Revised 12/5/2022 - 3rd Review

RE: Vue De La Parc Apartments – Development Plan and Nonuse Variance – 3RD Review Comments

FILE: Application No. DEPN-22-0222

Echo Architecture, LLC
4 S. Winatch Ave. #120
Colorado Springs, CO 80903
www.echo-arch.com
t. 719.387.7836

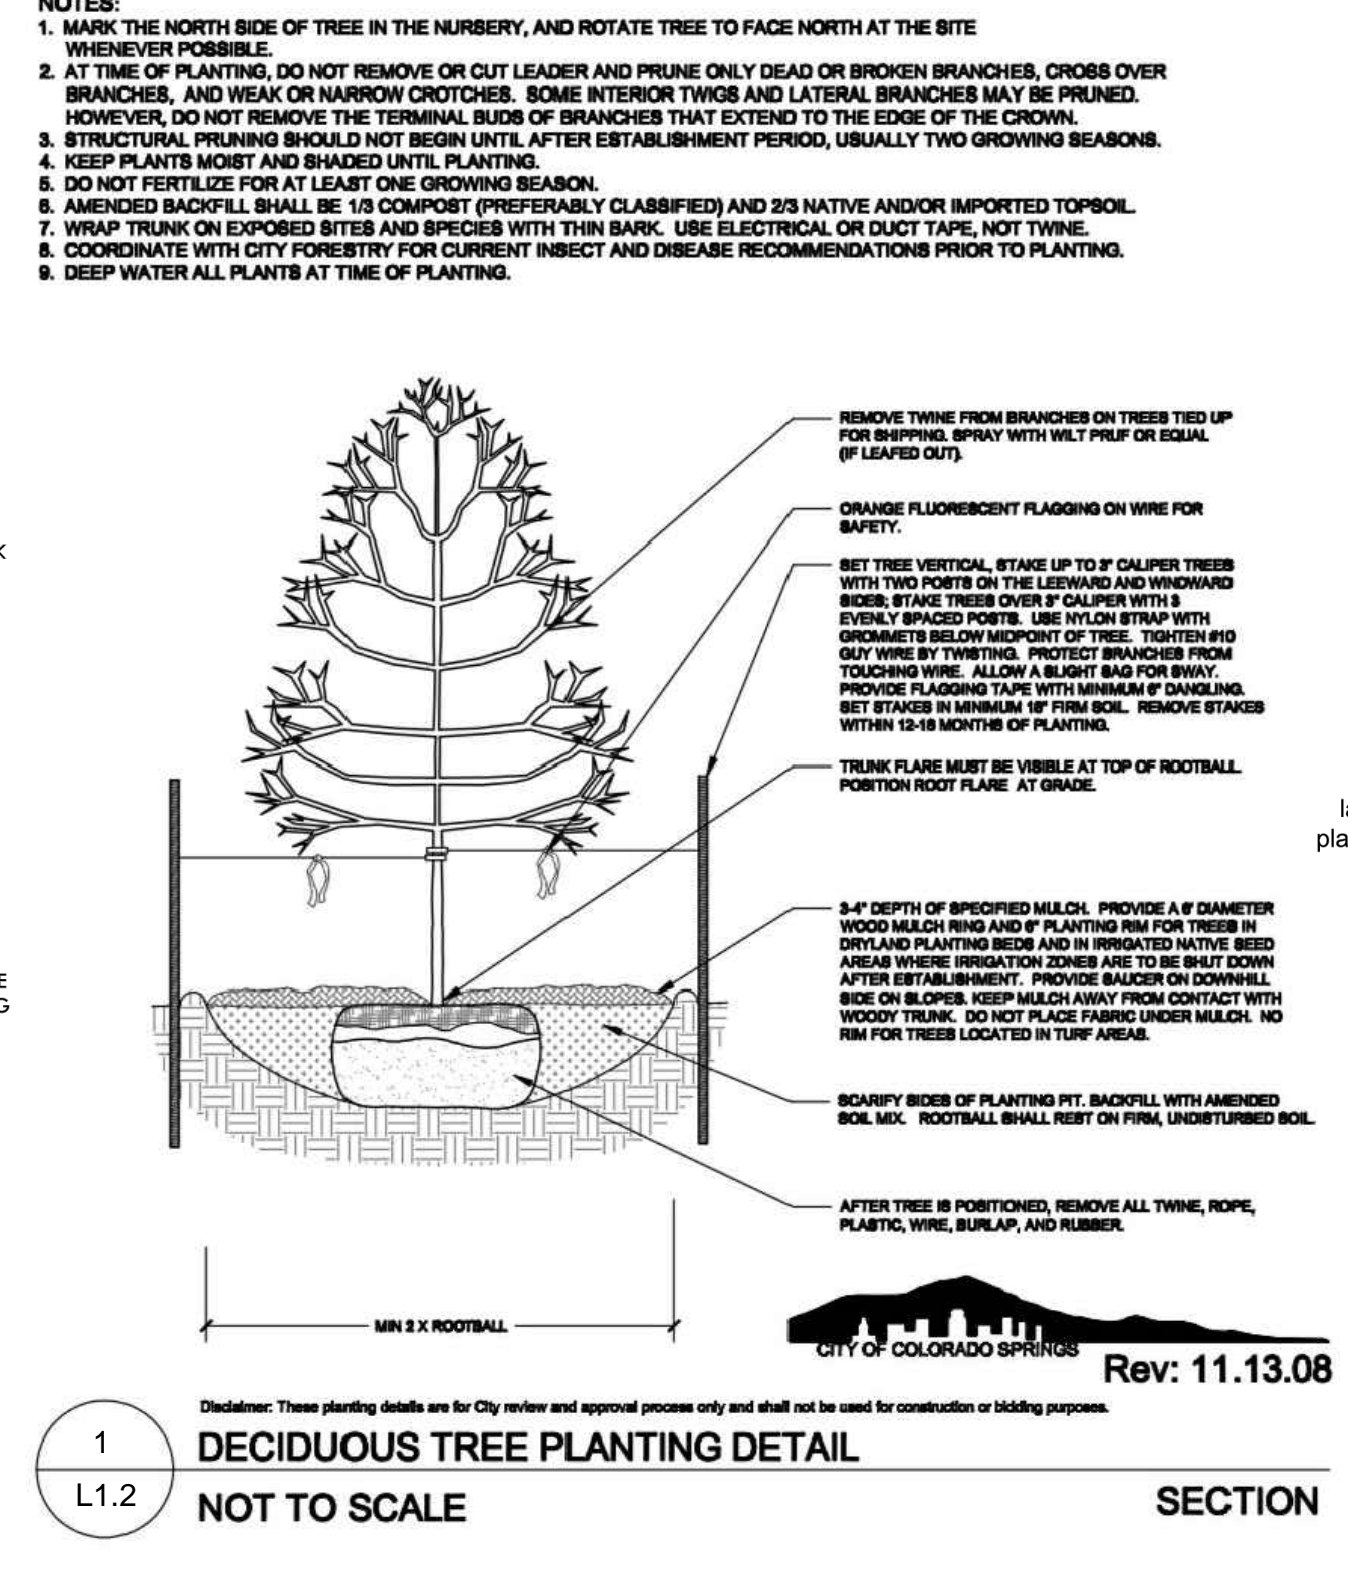
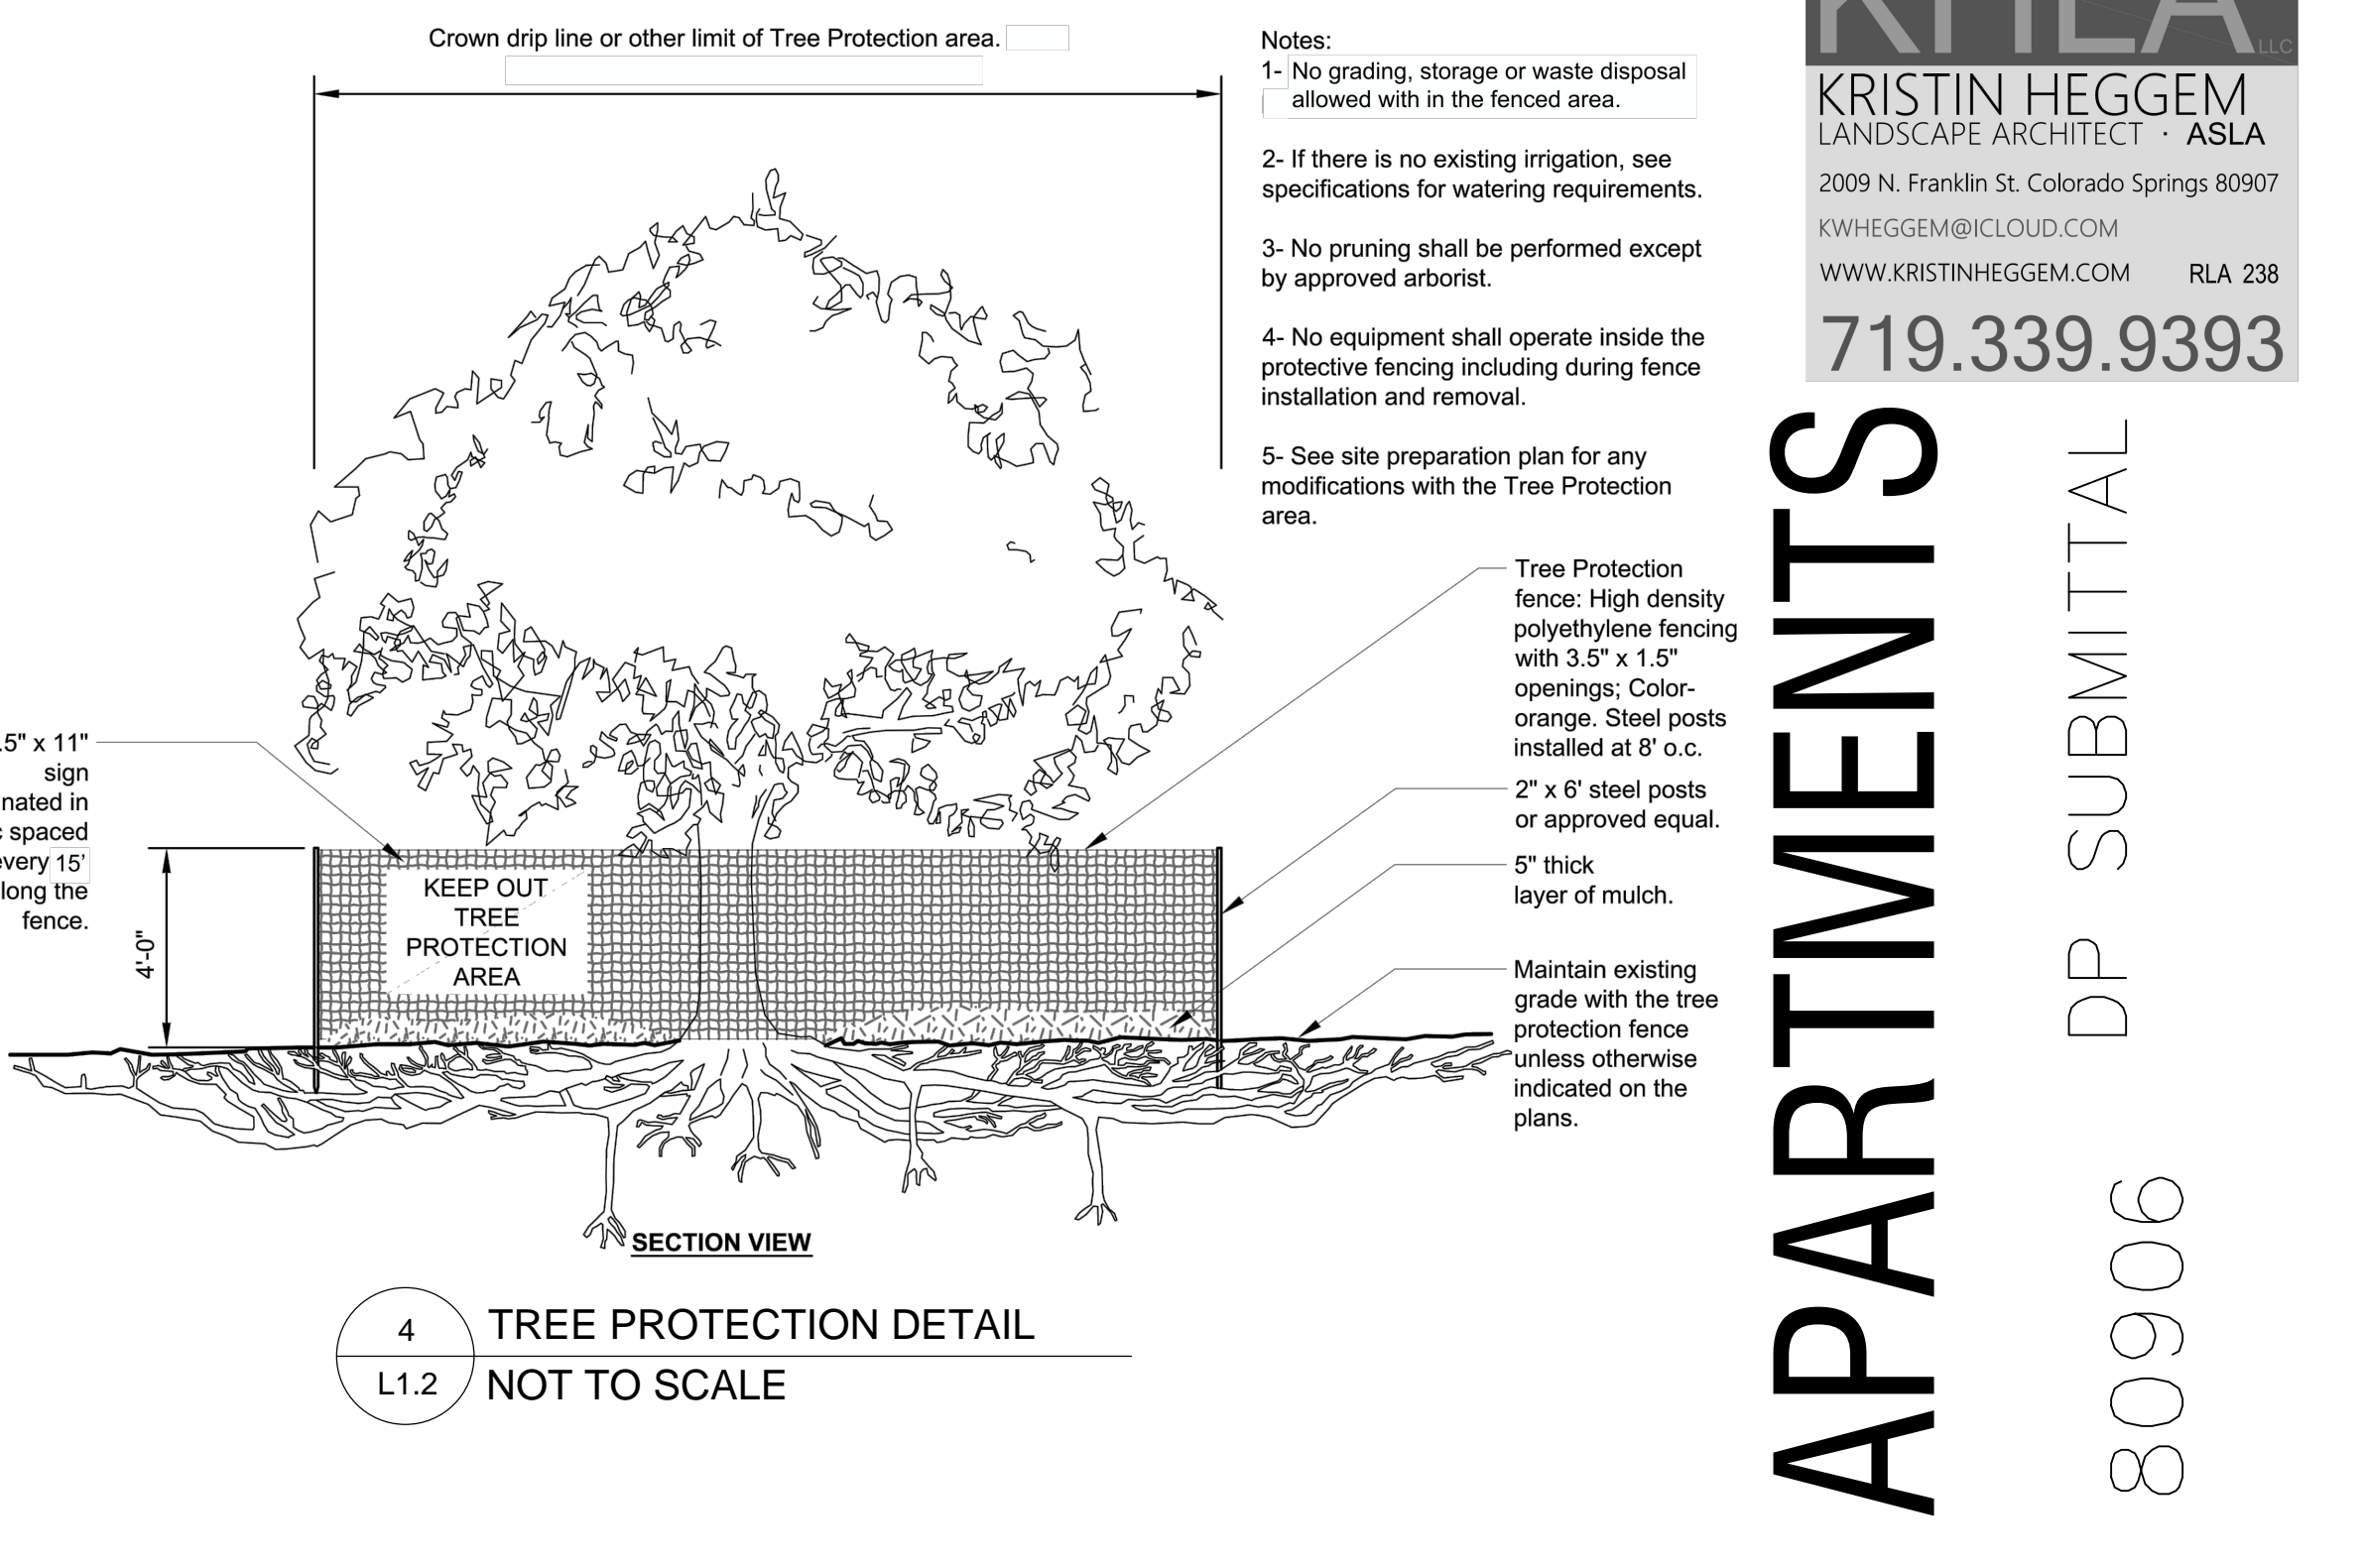
Add the following notes to this section:

"AN IRRIGATION PLAN SHALL BE SUBMITTED AND REVIEWED CONCURRENT WITH BUILDING PERMIT SUBMITTAL AND APPROVED PRIOR TO ISSUANCE OF A BUILDING PERMIT AND BEFORE ANY IRRIGATION

With the overall size of the project, the required existing soils analysis report will need be submitted with the Final Landscape Plan or at the latest with the irrigation plan. If the soils report will be submitted with the irrigation plan, update note 3 to read -"The required Soil Analysis Report is required to be submitted and approved with the Irrigation Plan submittal and before any landscape construction. This would include completing the soil sampling and submitting the samples to a soils lab for testing. A separate lab test report and soil preparation recommendations (amendment/fertilizer amounts and application rates) for each type of proposed landscaping (Shrub beds/Sod/Native Seed) will need to be provided to City Staff for review and approval." Soils test to be done after site grading per conversation with Daniel Gould

Update note 16 to include minimum amount of soil amendments for the native seed areas (2 CU per 1000 SF) This can be revised based on pending soils report. Addressed
